RE: Addition, 190 Rand Road
ID #2004-0180, CBL #255-A-008

On October 1, 2004, the Portland Planning Authority approved a 2,500 sq. ft. addition to the existing Stultz Fluid Power building located at 190 Rand Road, with the following conditions:

From: Jay Reynolds
To: Kandi Talbot
Date: Wed, Sep 29, 2004 10:04 AM
Subject: 190 Rand Road Engineering Review

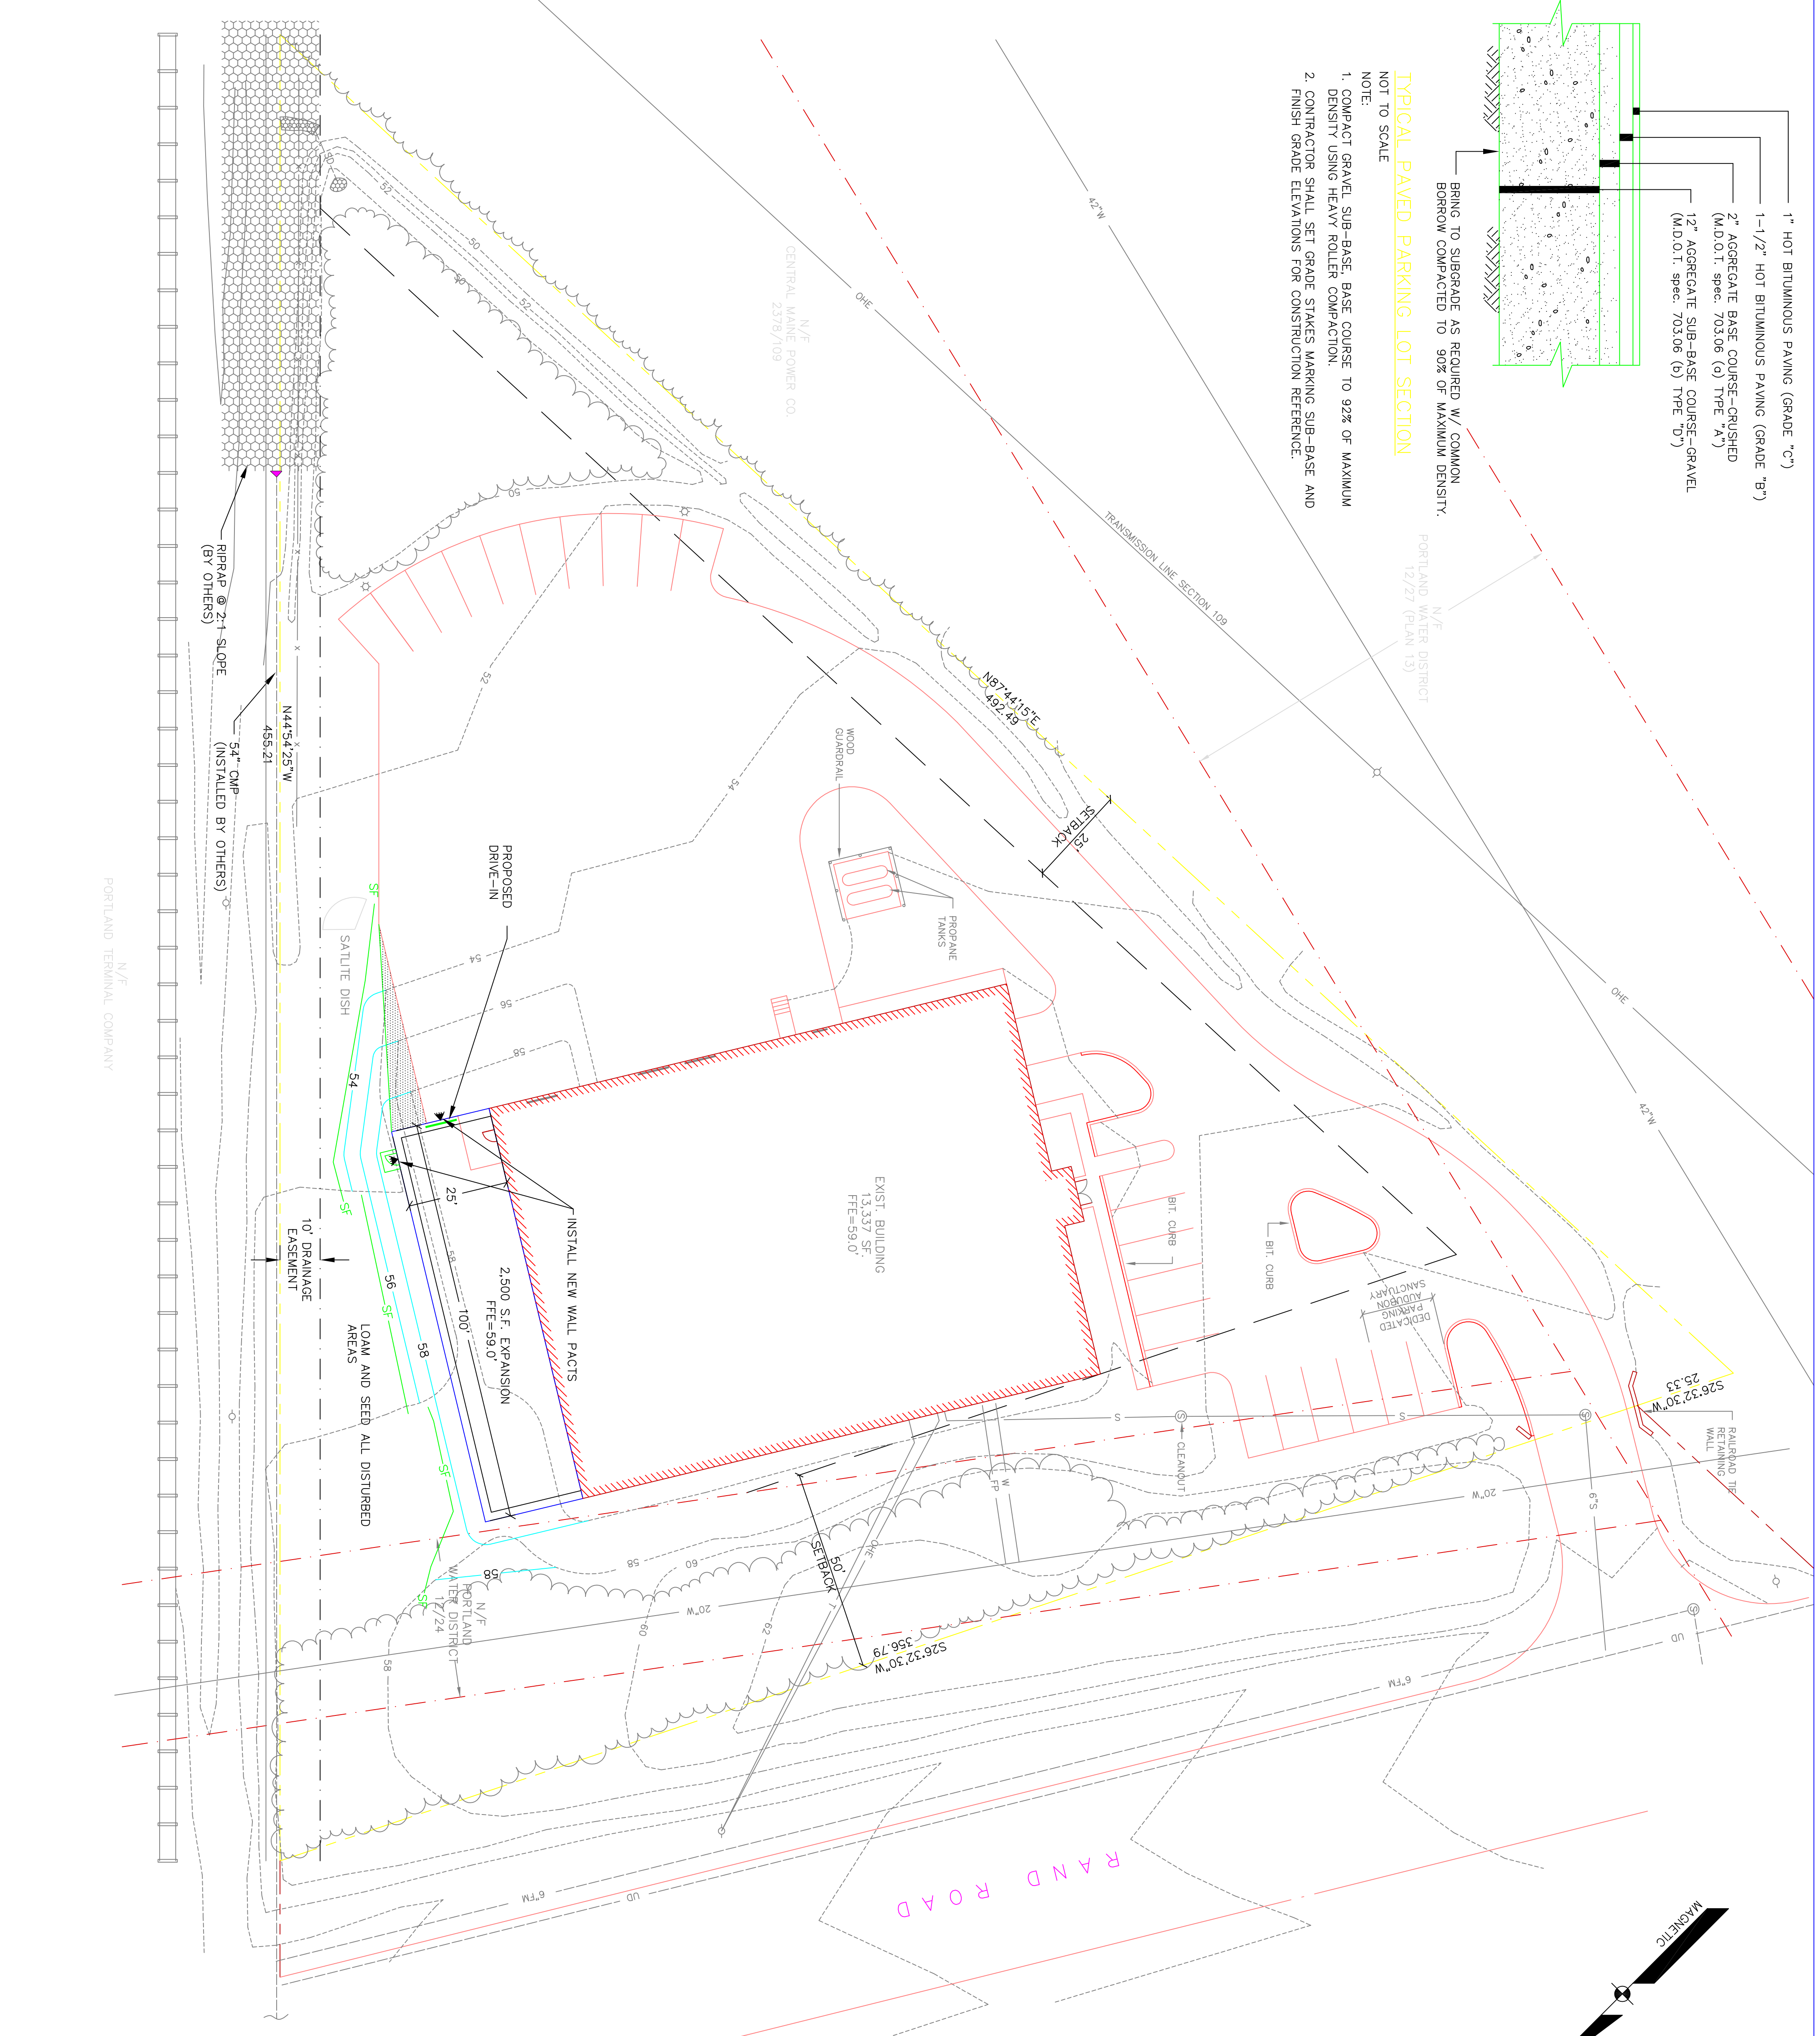
1. The silt fence should be continuous, not 3 separate sections. It should also wrap around the front of the building (Rand Road side) to envelope all limits of work.
2. It is recommended that the mature tree line be preserved through construction, and noted on the site plan.

1. The silt fence should be continuous, not 3 separate sections. It should also wrap around the front of the building (Rand Rd. side) to envelope all limits of work.
2. It is recommended that the mature tree line be preserved through construction, and noted on the site plan.
3. There is no curb and sidewalk along the street frontage. A waiver may be in order.
4. It doesn't appear that the proposal would increase the impervious surface ratio dramatically, however the ratio should be calculated to verify that it is under the 75% amount for IM zone.
